Application number: 2024/92125	
What is the application for?:	Erection of single and two storey rear extensions with detached garage and assoc
Address of the site or building:	2-4, Falledge Lane, Upper Denby, Huddersfield, HD8 8UW
Postcode:	WF4 4DJ

Type of comment: An objection	
Do you wish your comments to be published on the website anonymously?	Yes

south elevation

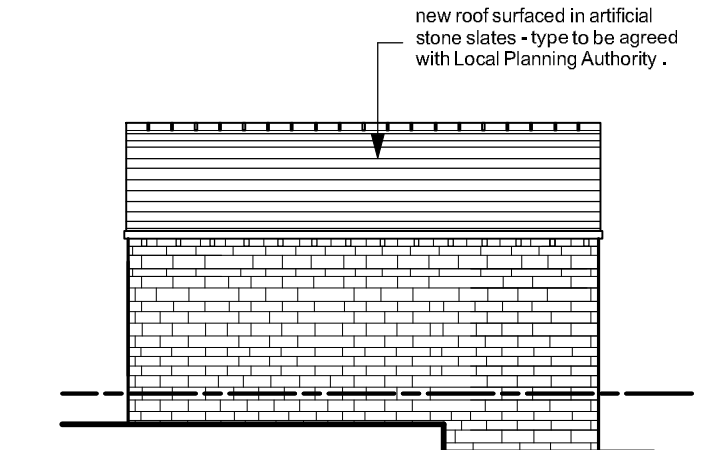
The proposal for the south elevation overlooking Falledge to introduce full width sliding doors and roof lights to the front single storey extension is very detrimental and quite jarring to that elevation.

east elevation

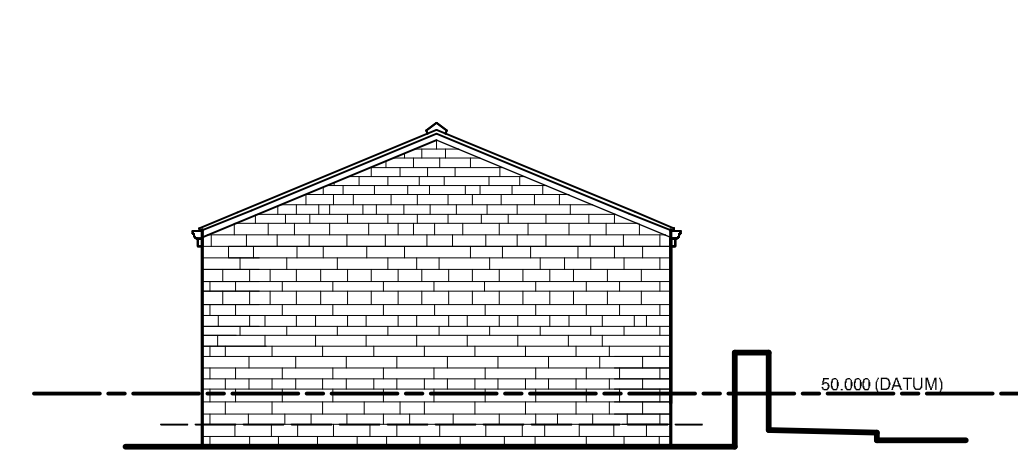
The proposal for a 2-storey 'rear' extension, rear in this case meaning the opposite side to the main entrance elevation, is increasing the original house footprint and it's mass by approx. 50%.

This extension will be over dominant to the existing house, especially as it will be head-on to the rising western approach from the village.

The incorporation of windows/door/glazing virtually full height over the 2-storeys and approx. three fifths of its width is again quite detrimental to this east elevation.

Site Plan 1/500

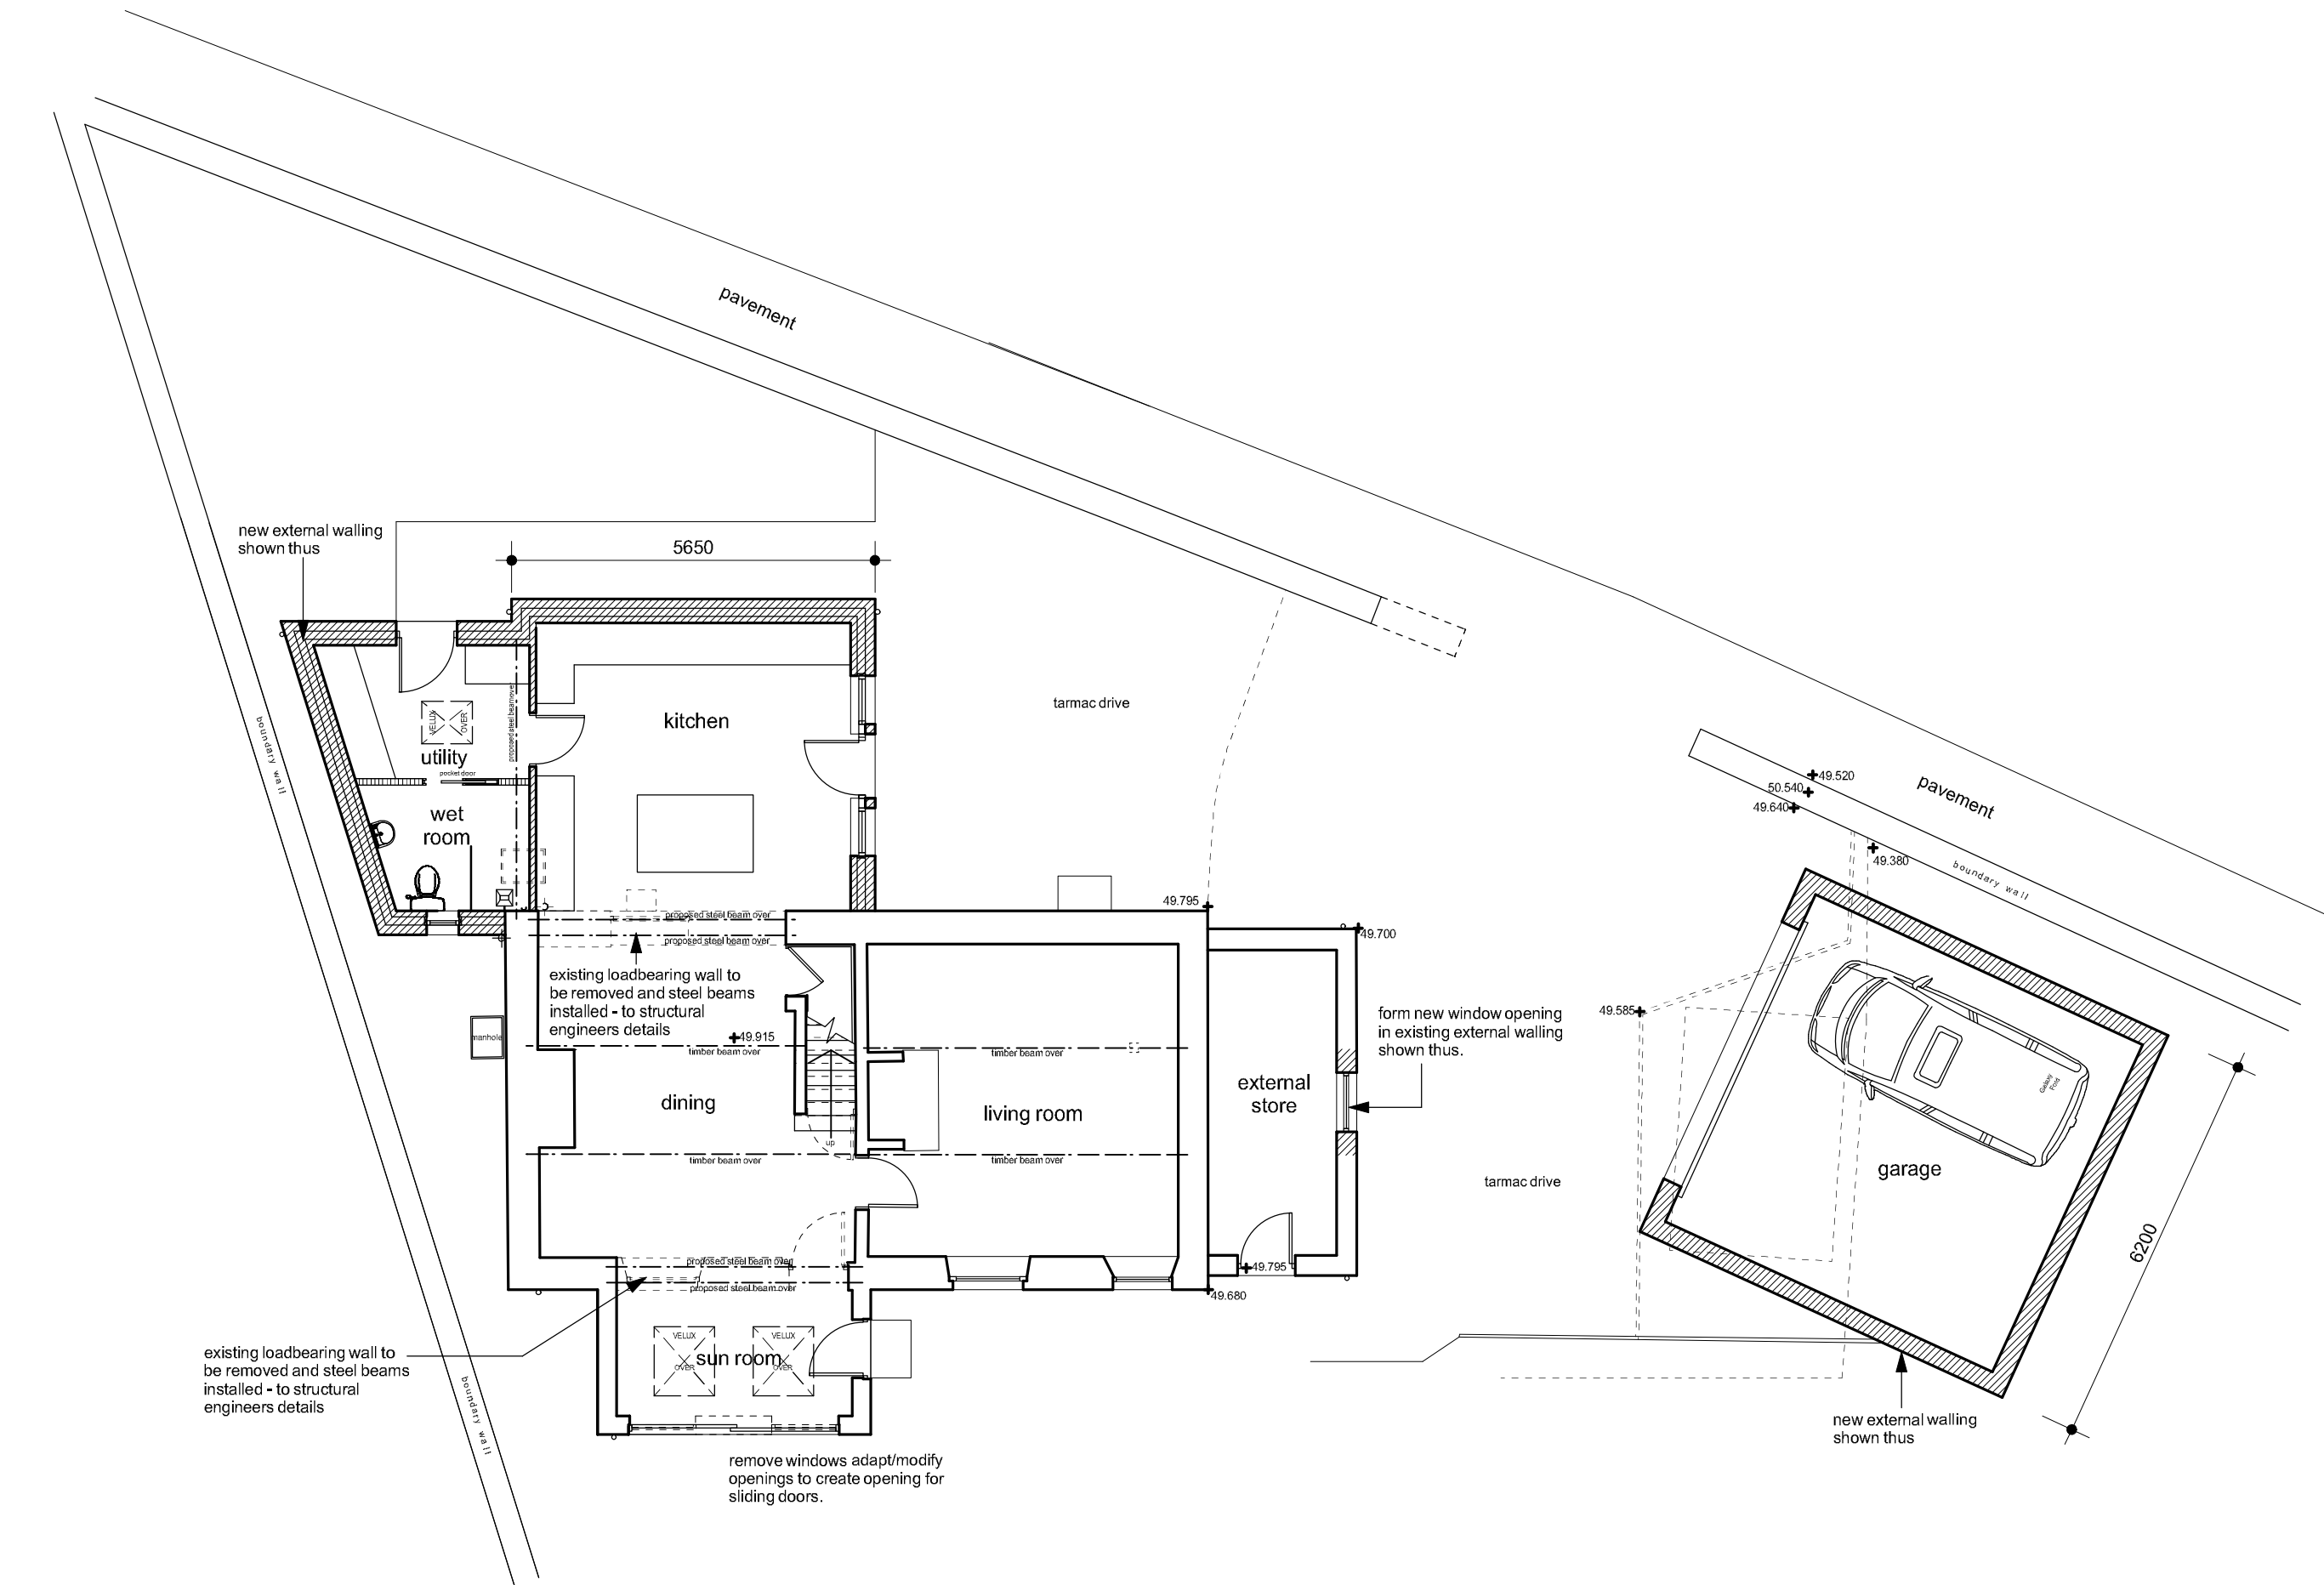
The angled garage is another element which would spoil the symmetry and open value of this important corner site and does not help with visibility lines at the convergence of the 2 roads.
